Engineering Review

**FINAL DRAINAGE REPORT  
FOR  
RETREAT AT TIMBERRIDGE  
FILING NO. 2**

PCD-ENGINEERING REVIEW COMMENTS  
IN BLUE BOXES WITH BLUE TEXT

PCD Project No. SF-21-XXX

DETENTION FACILITY POND 3

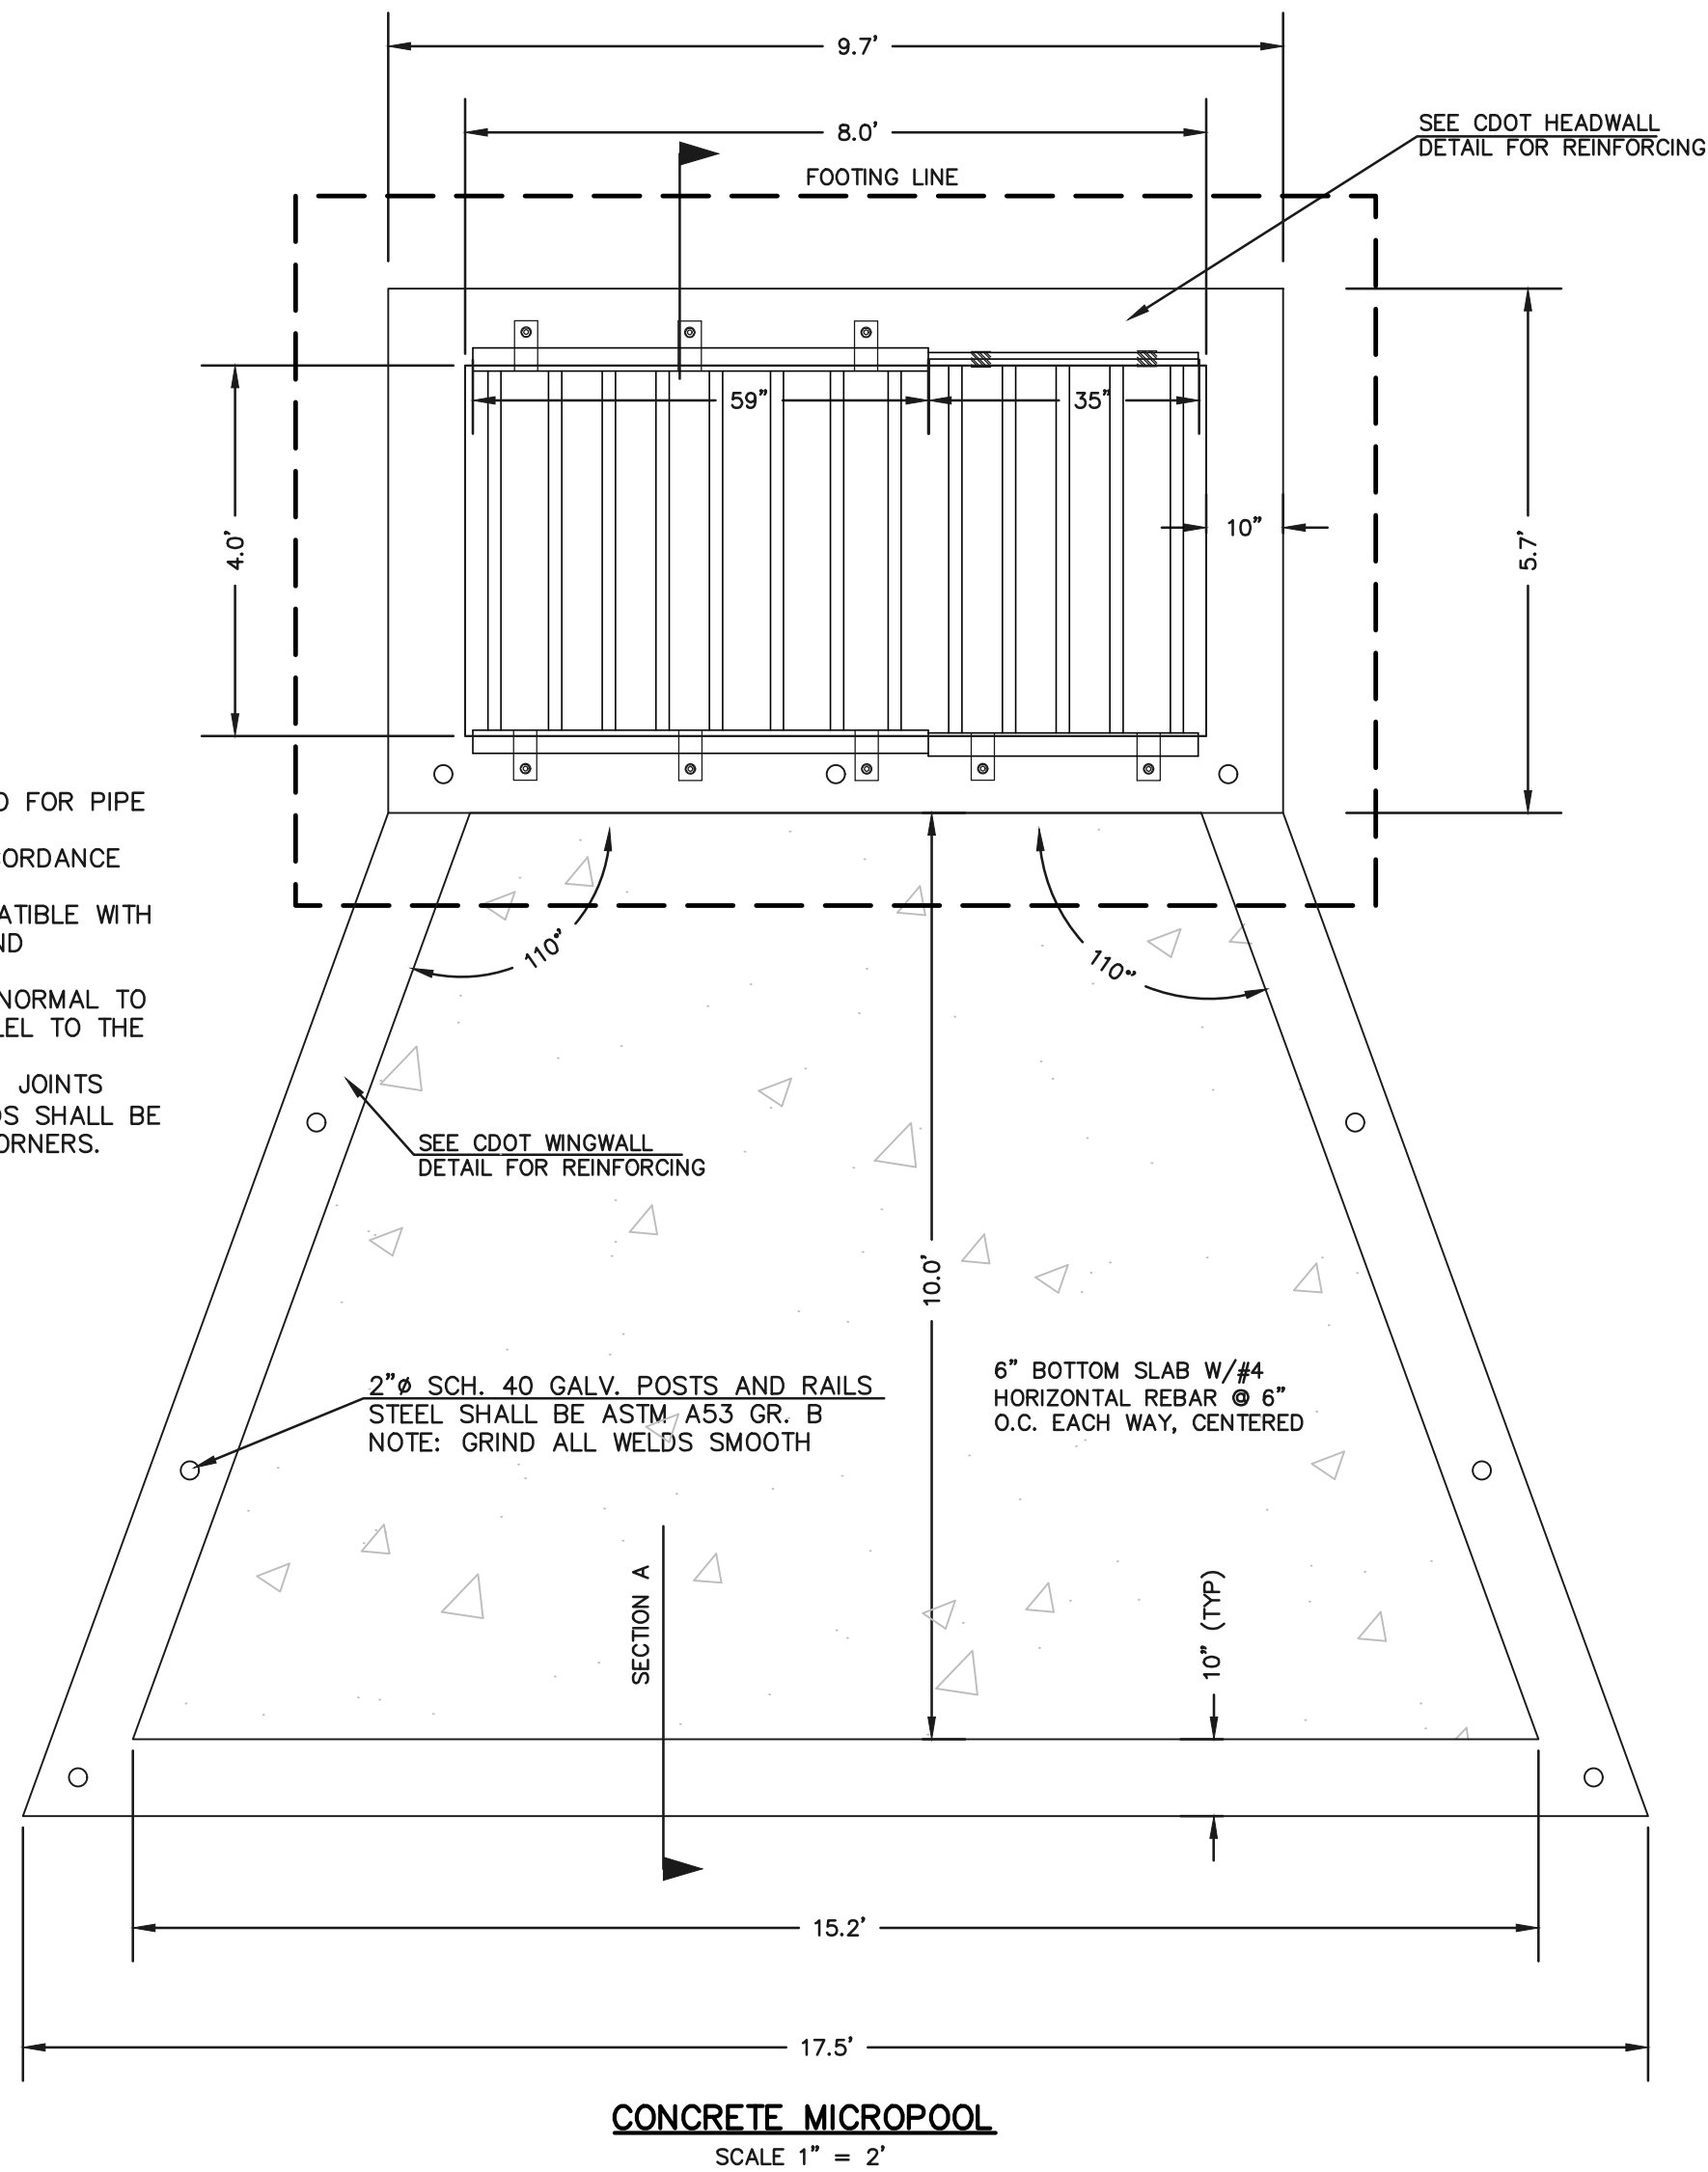
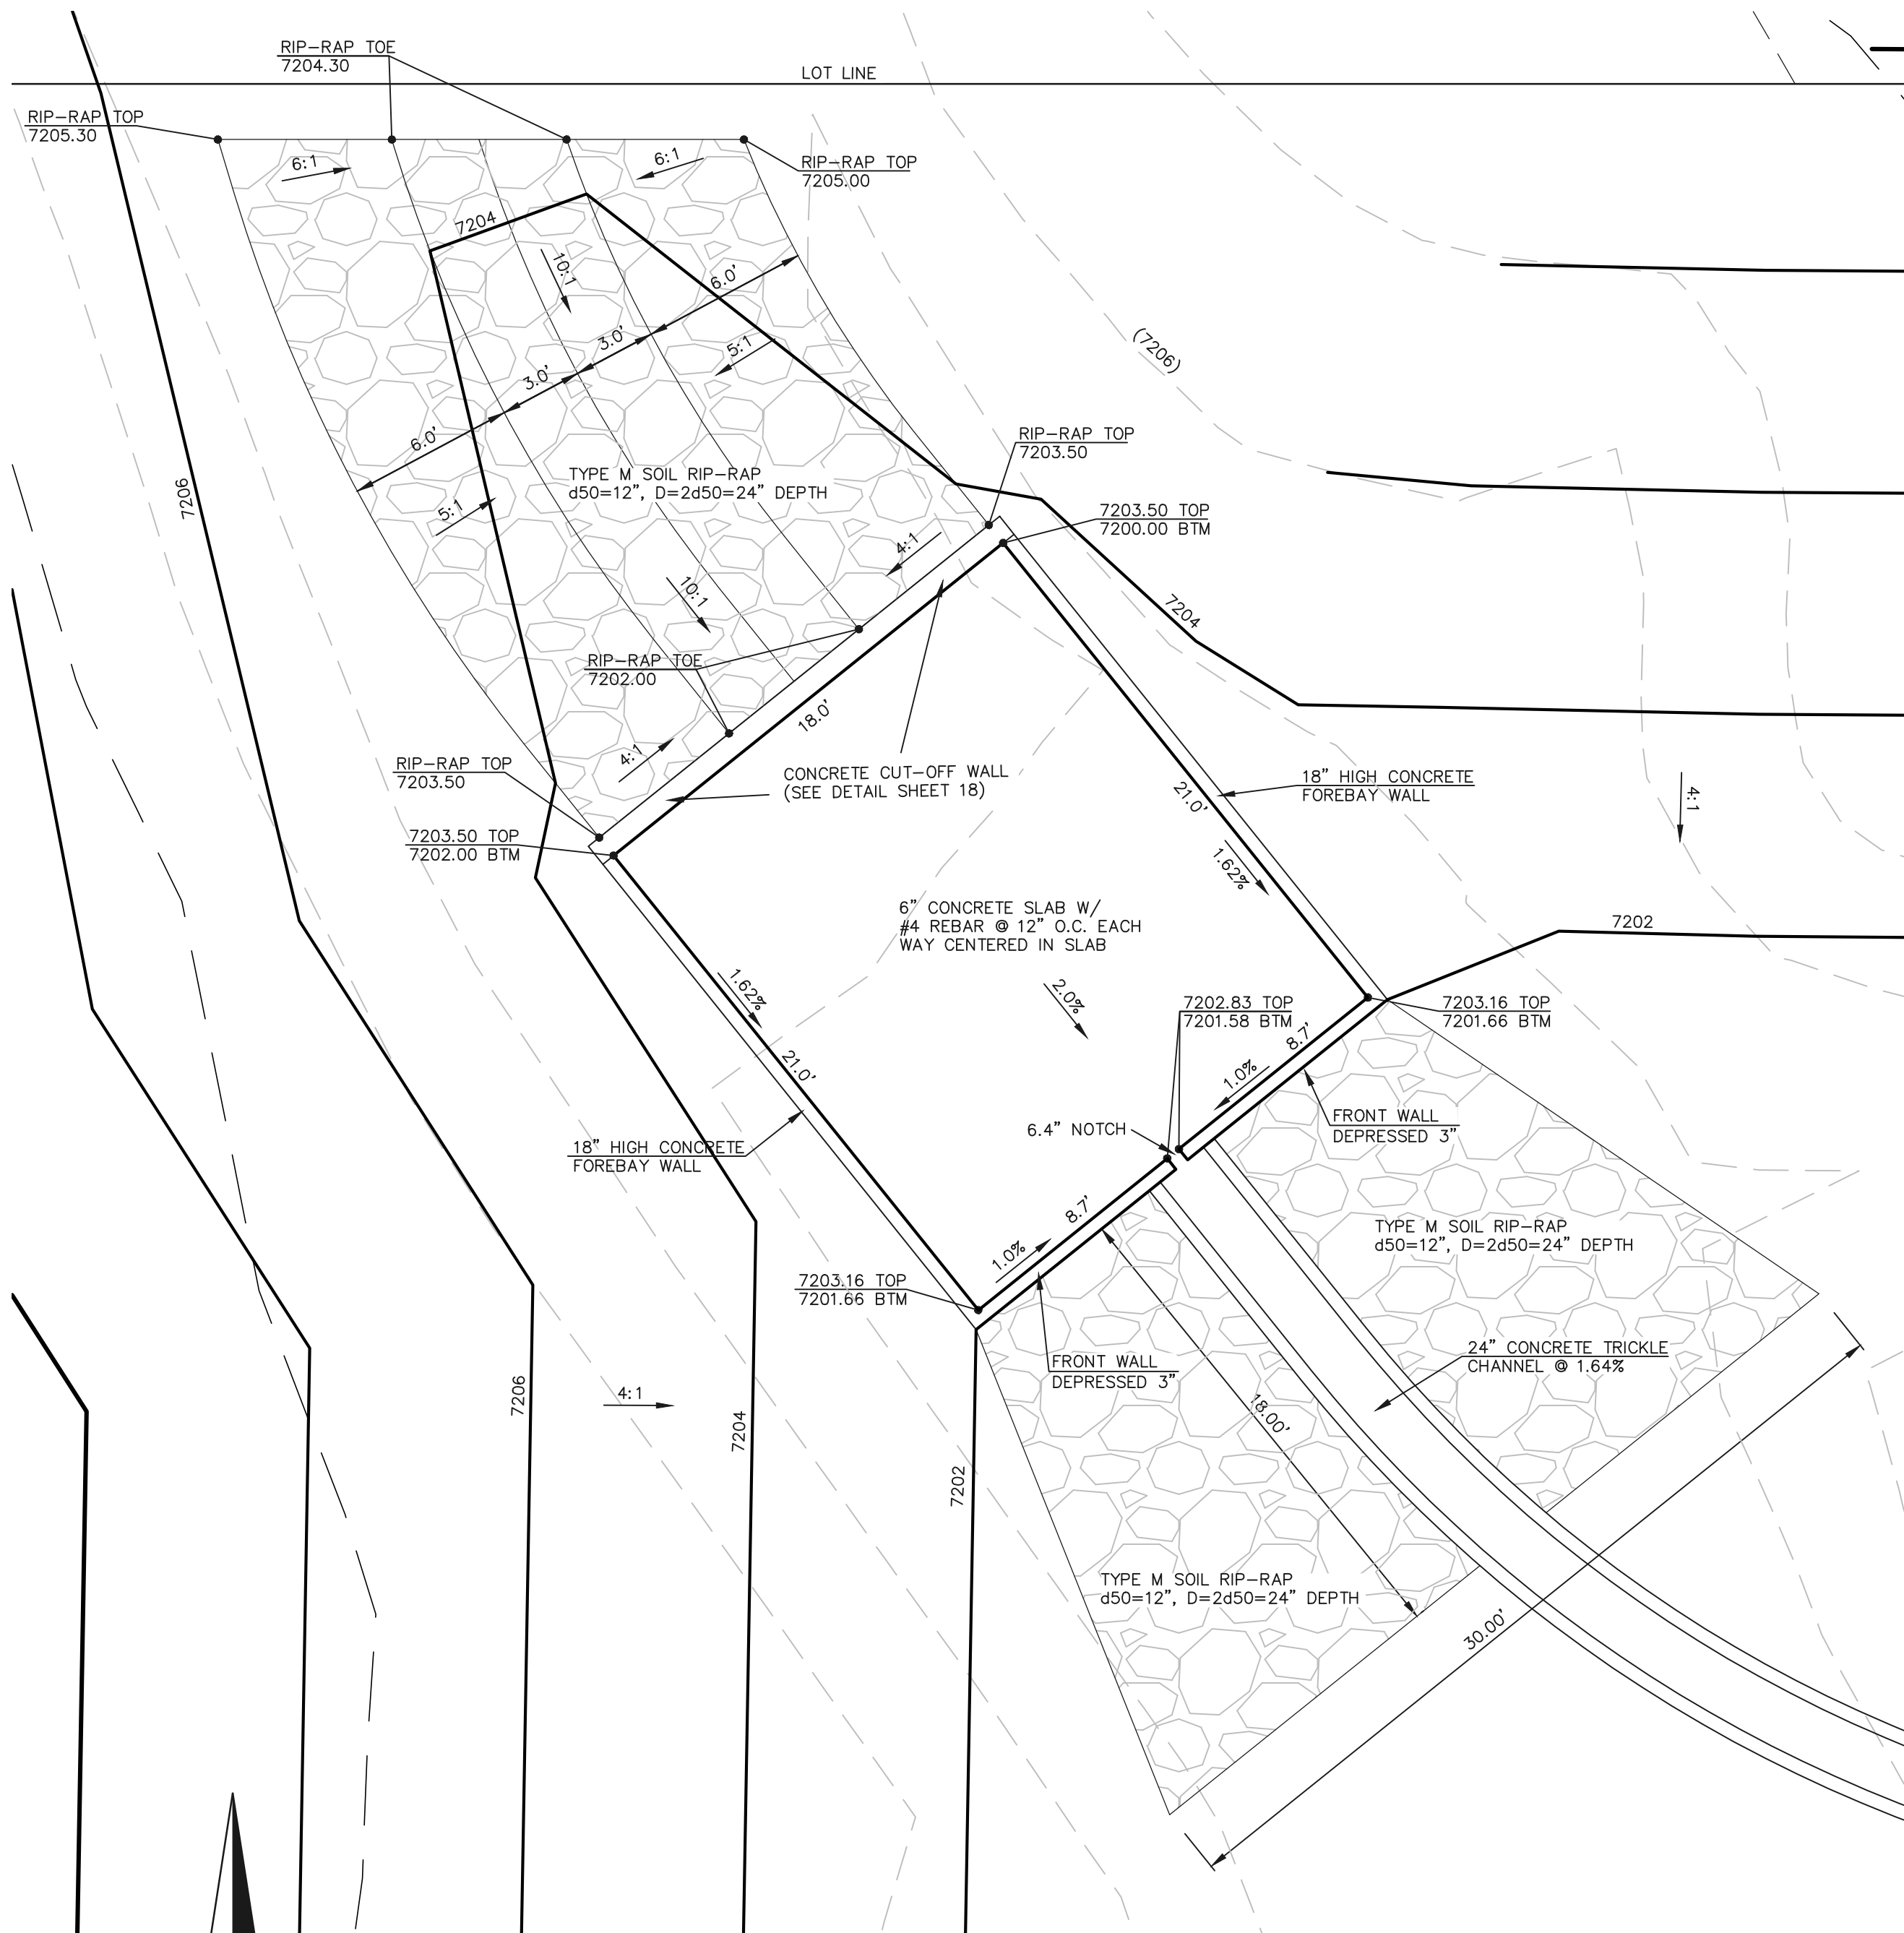
See comment letter regarding location of the pond
